# WILLOWTREE PLANNING

REF: WTJ20-302

## **RE RESPONSE TO SUBMISSIONS ADEQUACY REVIEW – PROPOSED MANUFACTURING FACILITY AND ASSOCIATED WAREHOUSE – SSD 25725029**

### **PROPERTY AT: 657-769 MAMRE ROAD, KEMPS CREEK (LOT 10 APPROVED UNDER 9522)**

Figure 16: Potential Intersection Layout (Signalised Intersection) for SLR / Bakers Lane (in 2036)

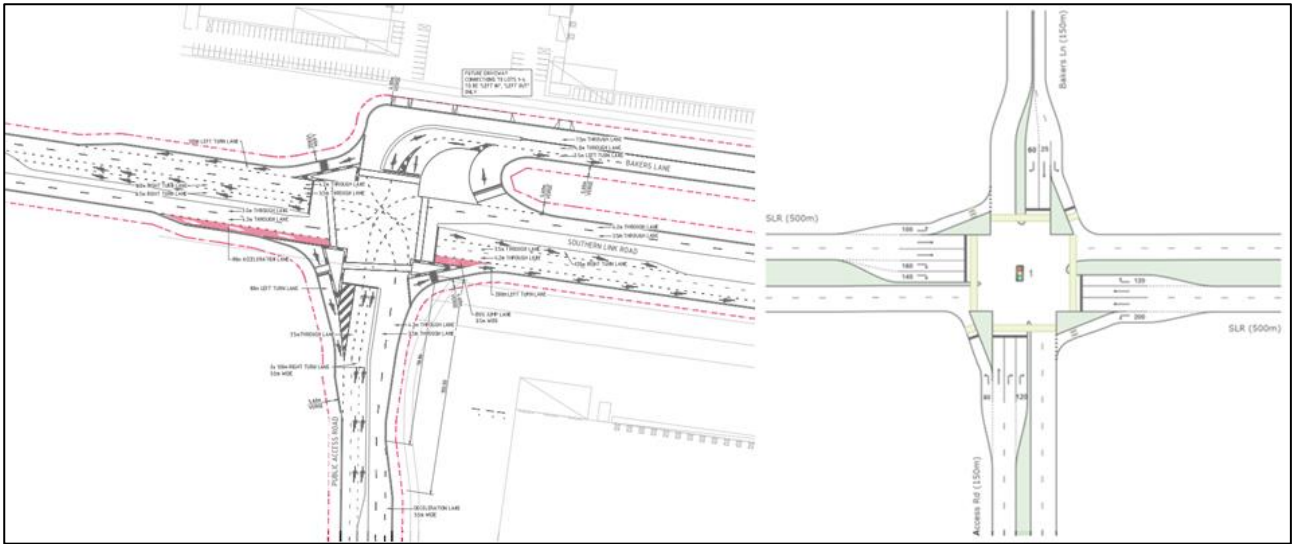
Comments	Response
<ul style="list-style-type: none"> <li>▪ The future SLR /Bakers Lane/NS Road 01 intersection design the proposal relies upon is not supported by TfNSW</li> </ul>	<p>Accordingly, the results of the assessments presented in this SSD are more conservative than what was undertaken for First Estate. This conservative approach provides flexibility for later developments to reflect minor changes that may occur over the life of the MSP.</p> <p>Therefore, it is our opinion that the TfNSW suggested MRP trip generation rates are considered even more conservative than the above rates and exceed the surveyed trip generation rates. Therefore, the above rates are more suitable for the purpose of this assessment.</p> <p>Notwithstanding, with the adoption of the 0.247 trip rate during the AM peak hour, the resulting traffic generation of 1,091 veh/hr is greater than the traffic generation for the MRP suggested rate of 0.23 and 0.24 veh/hr. Therefore, traffic modelling done with these rates already suggests a level of conservativeness that is beyond the suggested MRP rates.</p> <p>It is noted that the amended design advice from TfNSW (sent on 3 Nov 2021) for the future SLR / Bakers Lane / NS Road 01 was provided to Ason Group after the intersection layout had already been modelled and analysed in SIDRA as part of the original Lot 10 submission. In this regard and as part of the consultation with TfNSW for a separate SSD-9522 Modification (MOD 3), the design of the intersection layout was amended as shown in the figure below.</p>

Comments	Response
	<div><div>Proposed Lot 10 Submission (SK1)</div><div>Amended MOD Submission (SK2)</div><div>As TfNSW requested that the design for this intersection be amended, the SIDRA layout was amended as well. Notably, the phasing (double diamond), cycle time (140 seconds) and traffic volumes have not changed from the initial intersection layout design shown within the proposed Lot 10 SSDA TA. A summary of the SLR / Bakers Lane / NS Road 01 SIDRA results (for the SSDA TA layout) is shown below:</div><div></div></div>

UNCOUPLING ZONE (FOR 36.2 m A-DOUBLE TRUCK)

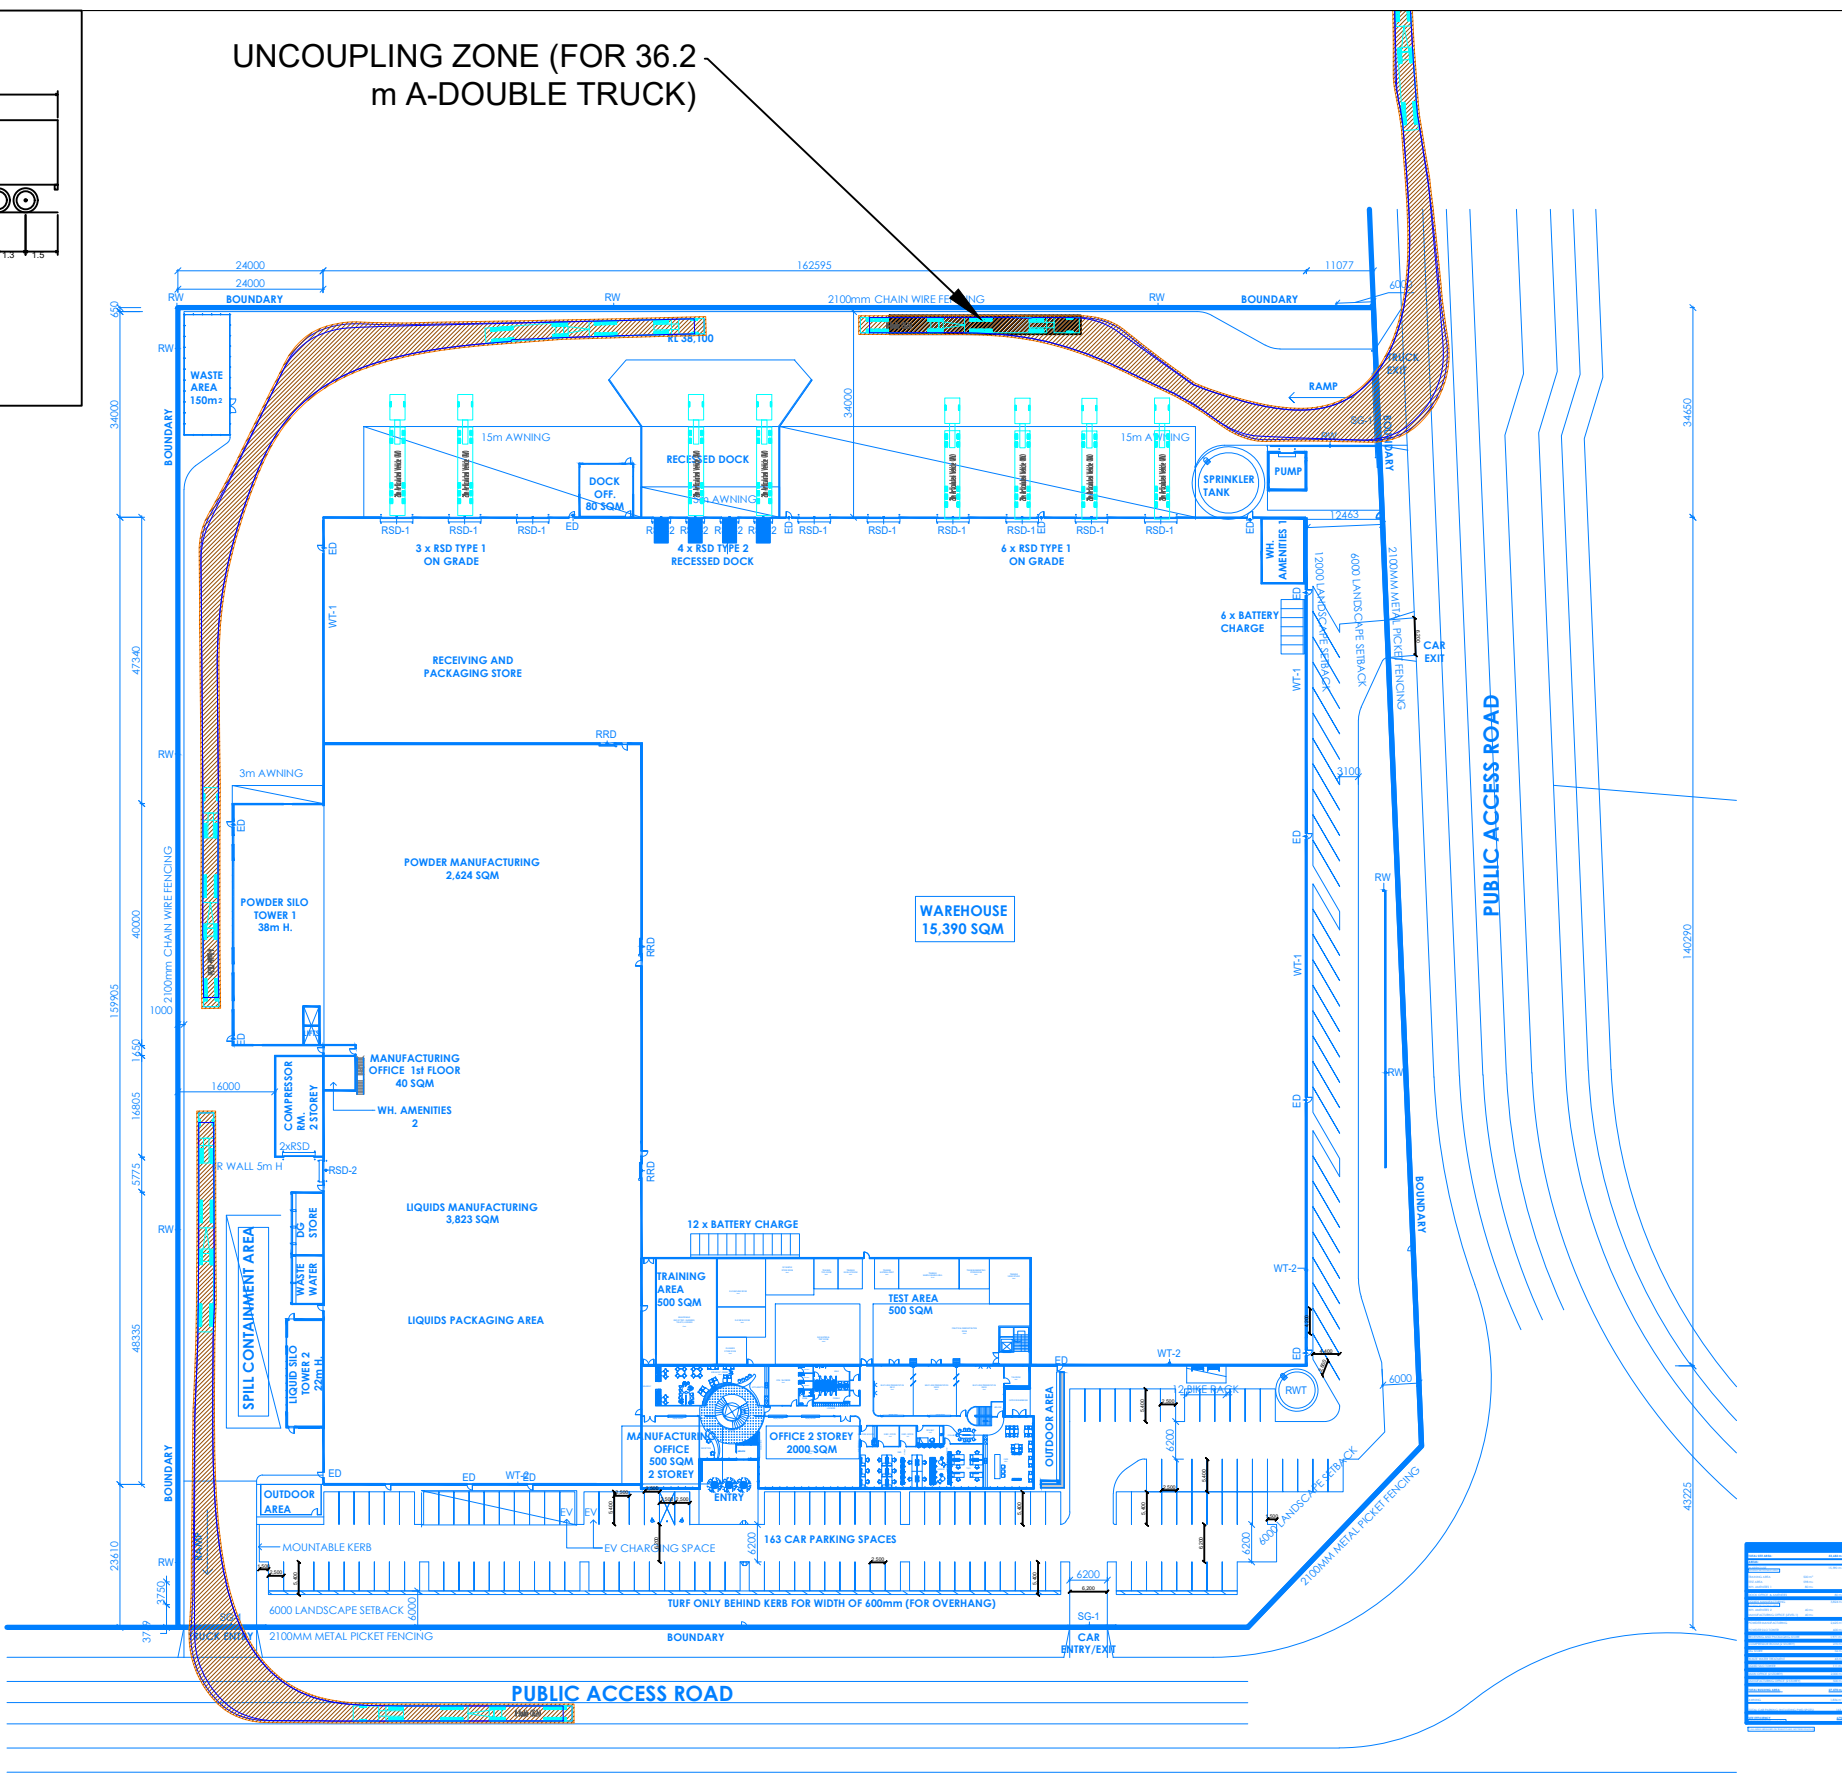
Comments	Response
<ul style="list-style-type: none"> <li>The overarching Construction Traffic Management Plan the Applicant wishes to rely upon has not been provided to TfNSW to support the current SSD</li> <li>The requested swept path for a 36m PBS vehicle has not been provided</li> </ul> <p>The Applicant is to update the response provided and relevant appendices to address the concerns raised by TfNSW.</p>	<p>The overarching CTMP prepared previously by Ason Group has been included within the original SSD-9522 submission and has been reviewed and approved by TfNSW.</p> <p>For clarity, construction of the proposed Lot 10 will be undertaken via the TfNSW approved existing Left in / Left out access along Mamre Road, until such time that the Sequence 1A signalised intersection has been delivered.</p> <p>In summary – the applicant accepts a Condition of Consent that requires a detailed CTMP once the SSD is approved.</p> <p>It is emphasised that the largest size truck expected for Lot 10 based on the operational information provided by the immediate tenant will be a 26.0m B-Double truck.</p> <p>Regardless and to address this comment, the swept path assessment showcasing a 36.2m A-double entering and exiting the Site is attached within the latest attached <b>Transport Assessment</b>.</p>
